**KIRKLEES METROPOLITAN COUNCIL
INVESTMENT & REGENERATION SERVICE**

**DELEGATED DECISION FOR APPLICATION FOR CERTIFICATE OF LAWFUL
DEVELOPMENT**

Reference no.: 2024/CL/93310/E

Site: 1, South View Terrace, Grange Moor, Wakefield, WF4
4DZ

General Arrangement as Proposed

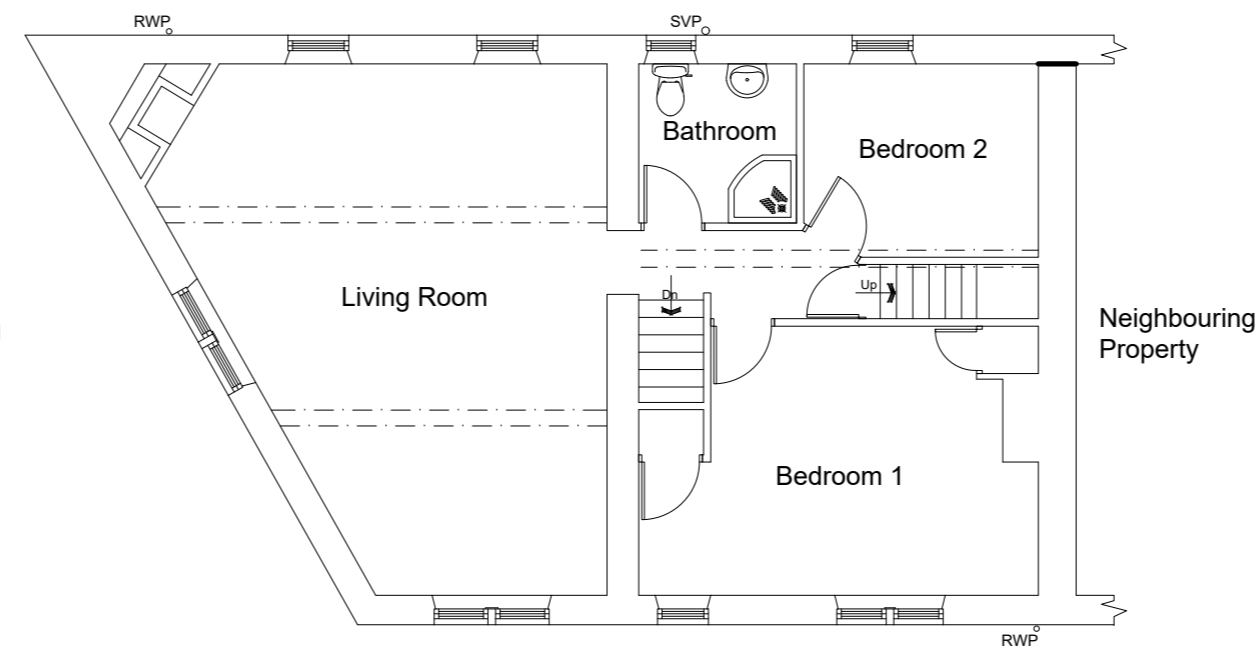
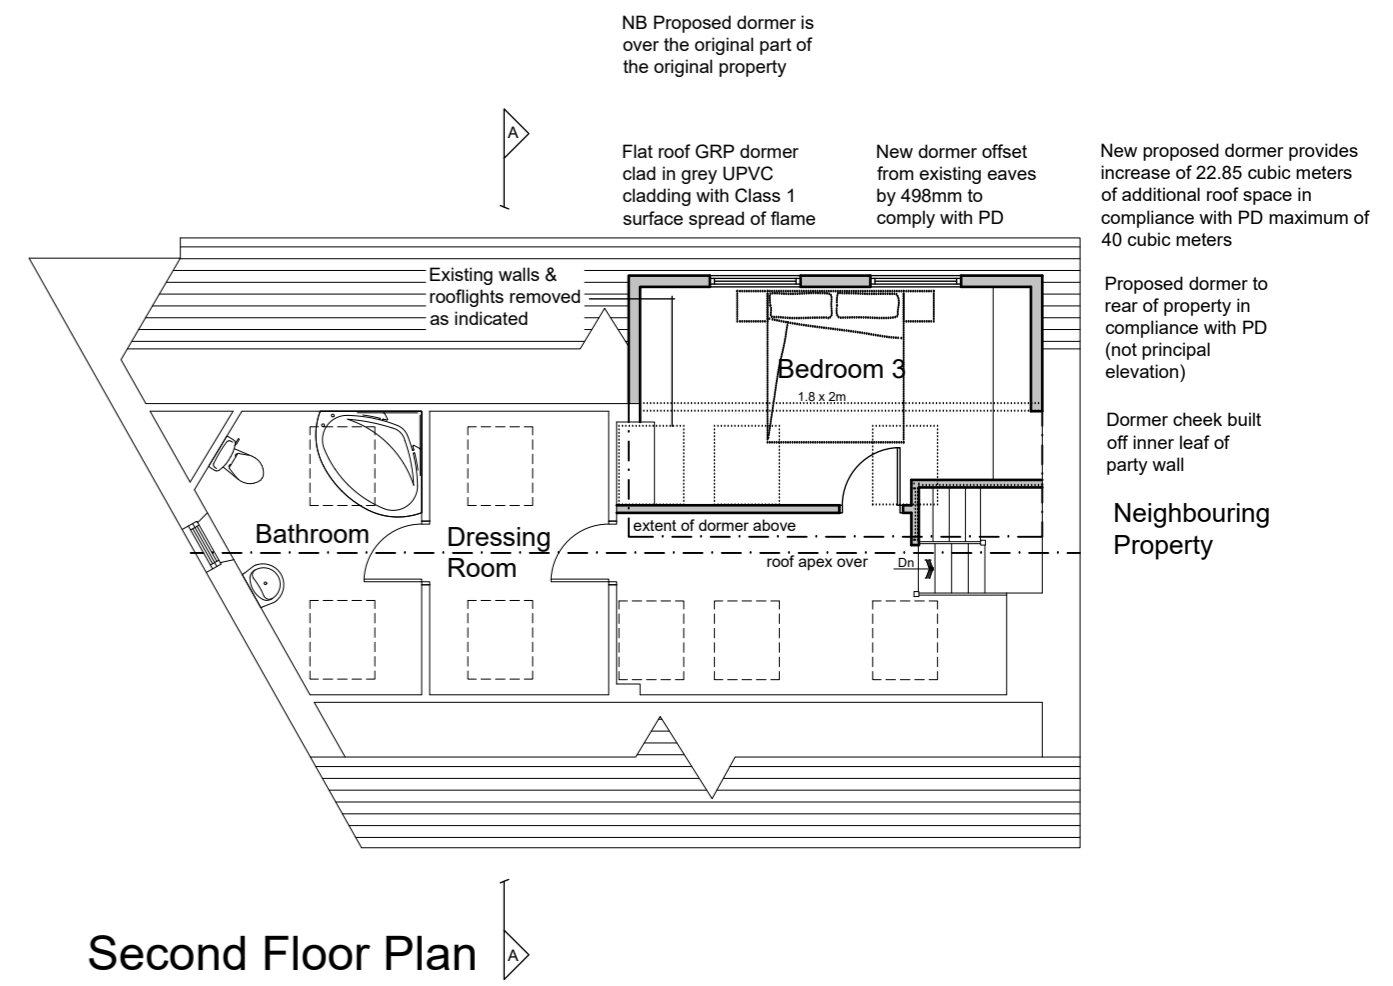
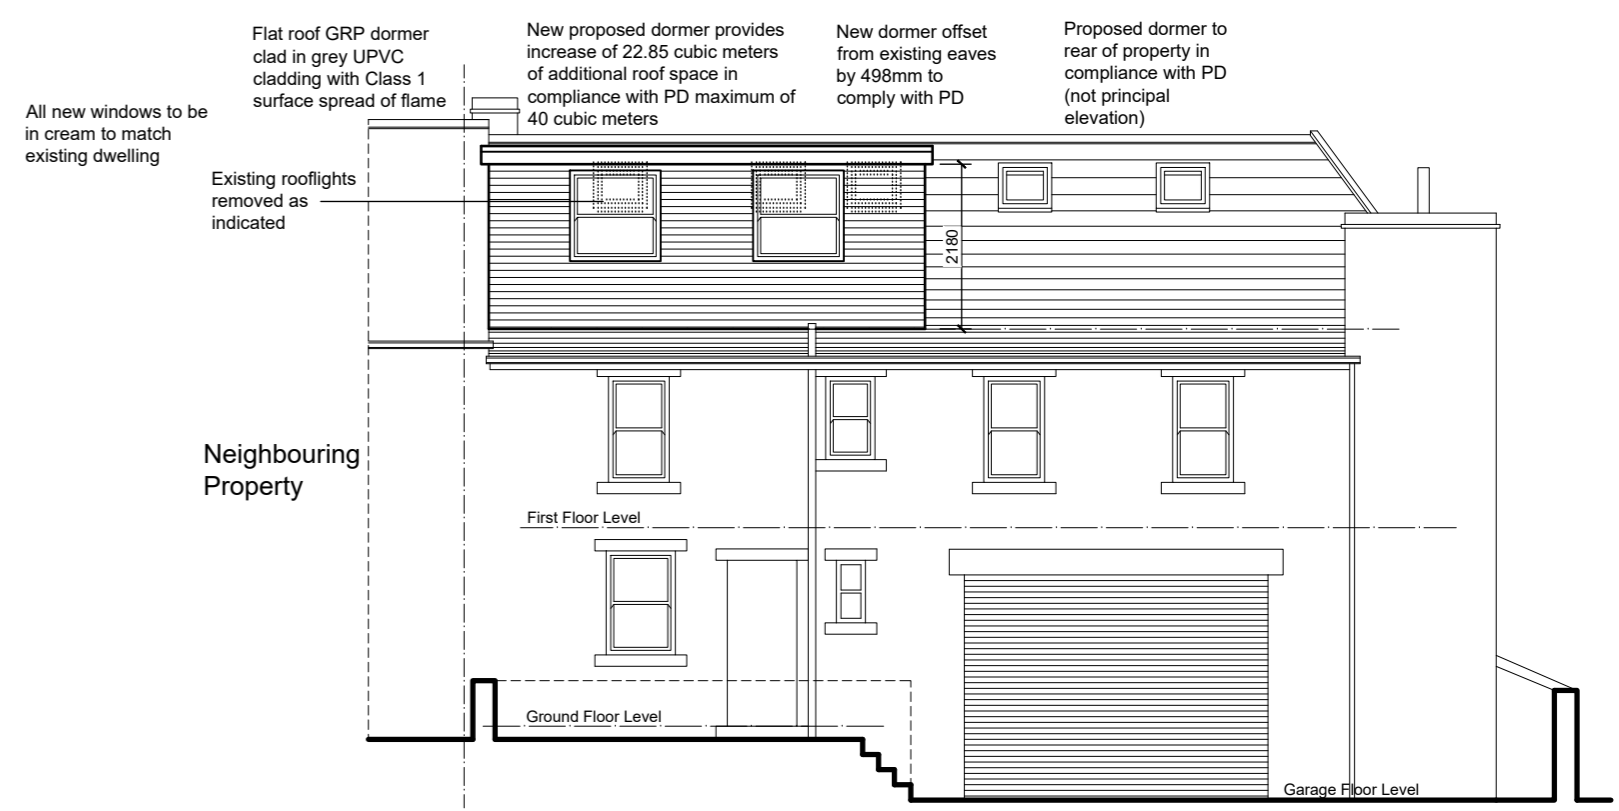
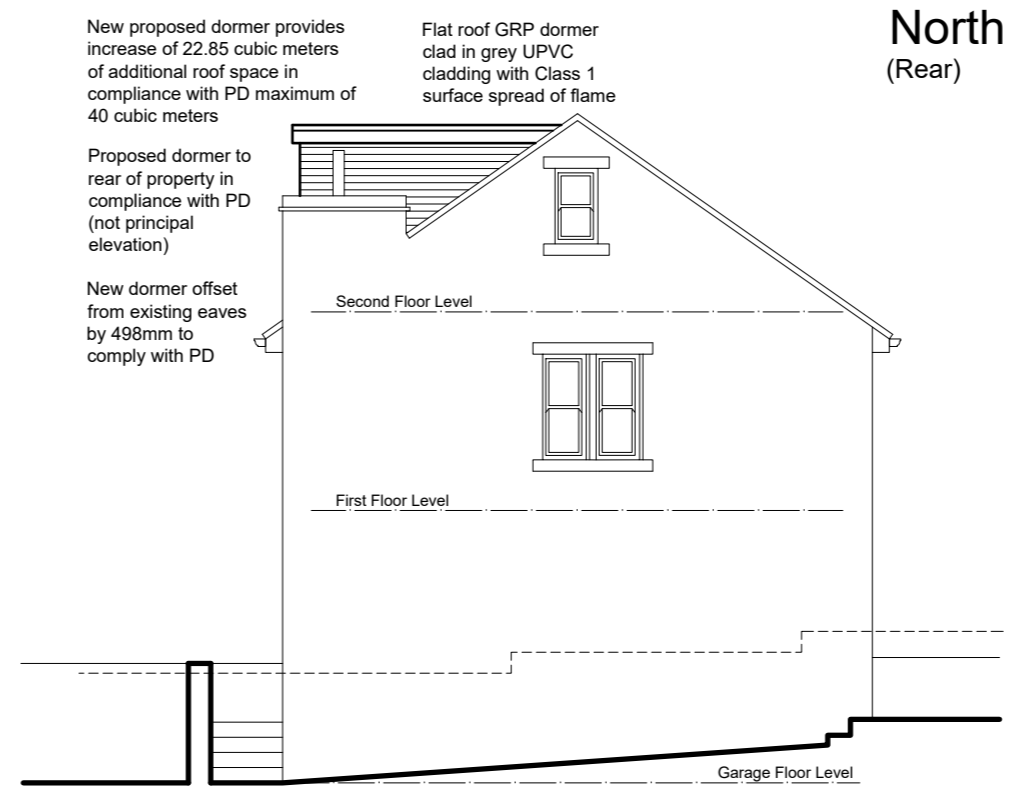
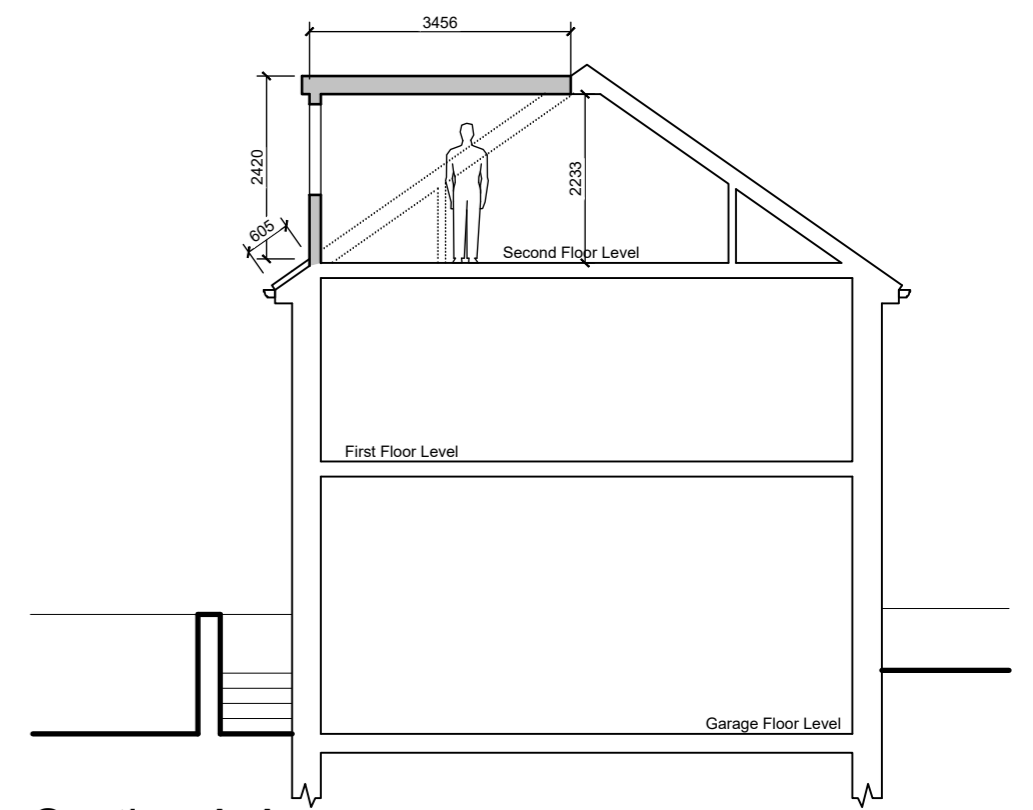
Comment: *As a terraced property, the maximum additional roof volume permitted is 40 cubic metres. The original roof space has been extended by approximately 63 cubic metres via the erection of a two storey extension adjoining the original west elevation. Taking*

into account the roof space created bar the original roof, the cubic content of the dormer extension in addition to the existing enlargement, the total resultant roof space would exceed 40 cubic metres.

The proposed rear dormer extension does not benefit from general planning permission granted by virtue of Article 3(1) and Schedule 2, Part 1, Class B of the Town and Country Planning (General Permitted Development) (England) Order 2015 (as amended) by reason of the resultant cubic content exceeding the limitation in sub-paragraph B.1(d).
